**KIRKLEES METROPOLITAN COUNCIL
DEVELOPMENT & MASTER PLANNING SERVICE**

**DELEGATED DECISION FOR PRIOR APPROVAL FOR CHANGE OF USE
FROM COMMERCIAL, BUSINESS AND SERVICE USES TO
DWELLINGHOUSES**

Reference no. 2024/CL/92938/W

**Site Address 1st, 2nd and 3rd Floors, 1, Lord
Street, Huddersfield, HD1 1QA**

Proposed Side Elevation
1:100

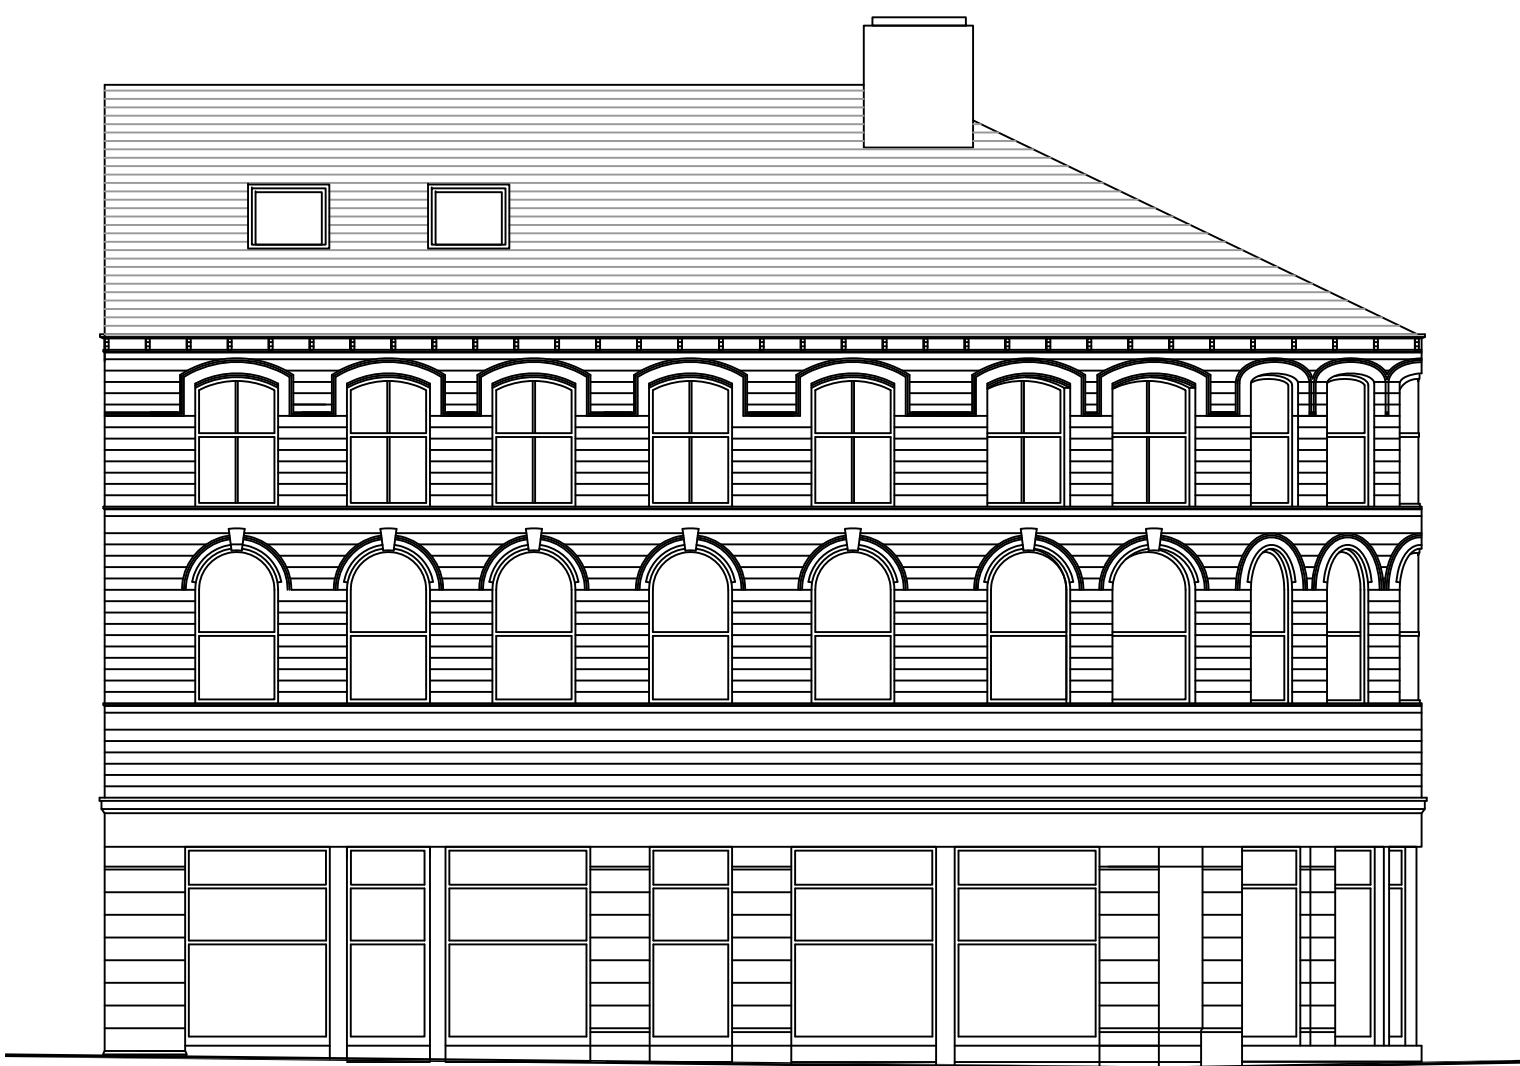
External alterations are proposed under this application in the form of the installation of 1 dormer window within the roof of the building. This element of the proposals is discussed in more detail within the Officer report.

- The applicants would benefit from liaising with their neighbours to resolve concerns relating to noise, parking and other details.
- This should be wholly supported subject to ensuring adequate provision for disposal and collection of waste.
- It's an attractive building and little appears to be changing as a result of this conversion, apart from a reasonably designed dormer window.

Amended plans were sought to include a section drawing, remove the originally proposed dormer window, and ensure that all studio apartments are 'true' studios with bedrooms not enclosed to ensure sufficient natural light can be gained throughout the whole of the apartment.

Proposed Third Floor Plan
1:100

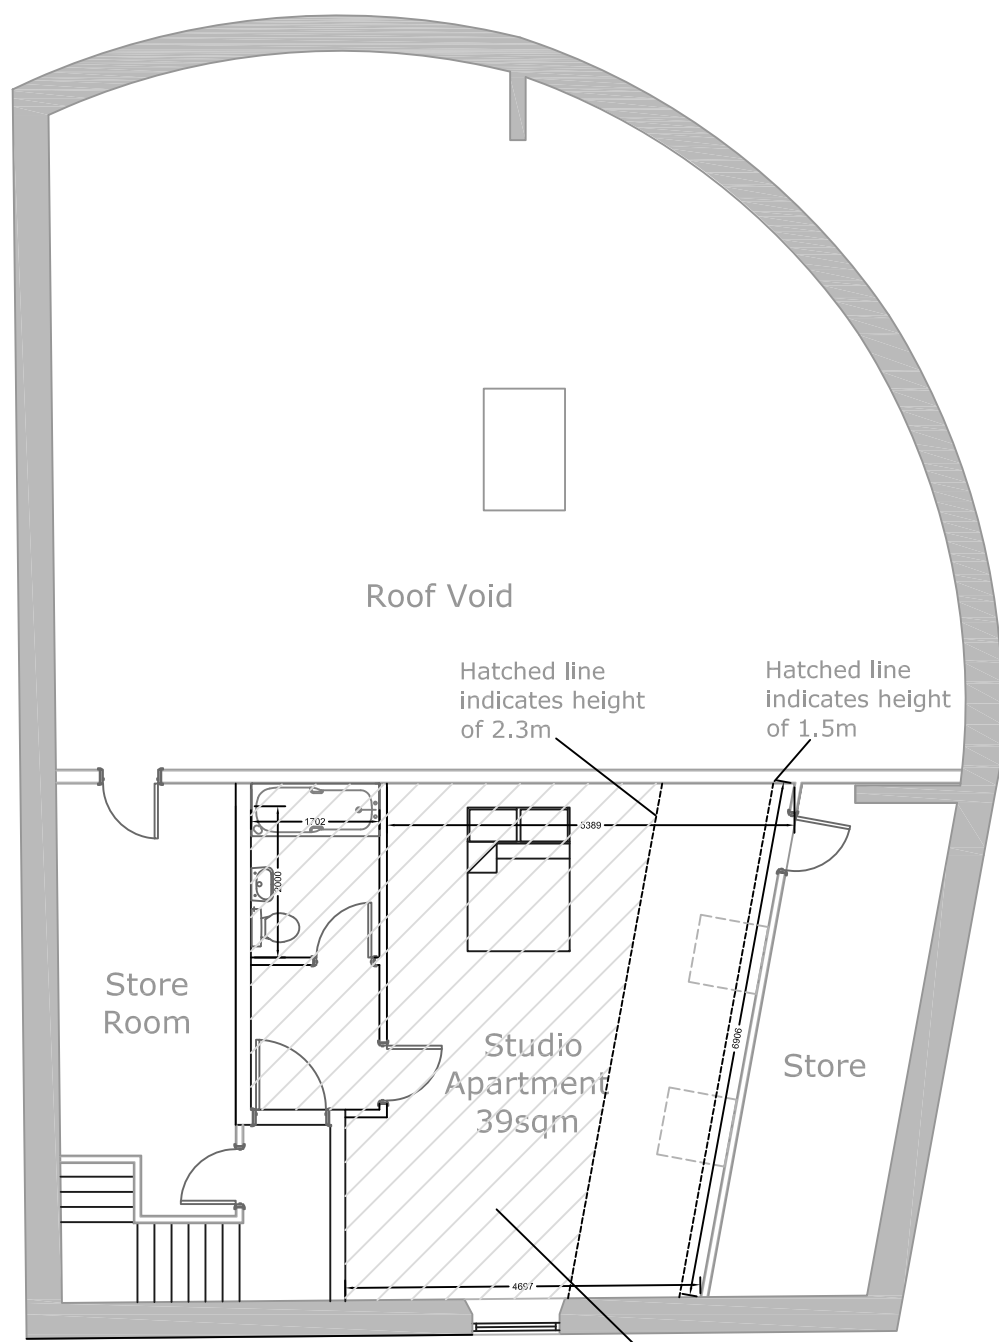
The units proposed are to measure at least 37sqm in size. This has been reviewed against the Nationally Described Space Standards, with all units meeting the requirements for a 1 bed, single person dwelling. This assessment has also taken into account the technical requirements of NDSS sets out at part f. that any area with a headroom of less than 1.5m is not counted within the Gross Internal Area unless used solely for storage (if the area under the stairs is to be used for storage, assume a general floor area of 1m² within the Gross Internal Area), in respect of the third floor apartment.

In addition to the above, the minimum floor to ceiling height is 2.3m for at least 75% of the Gross Internal Area (specifically in relation to the third-floor apartment), and therefore is deemed to be acceptable.
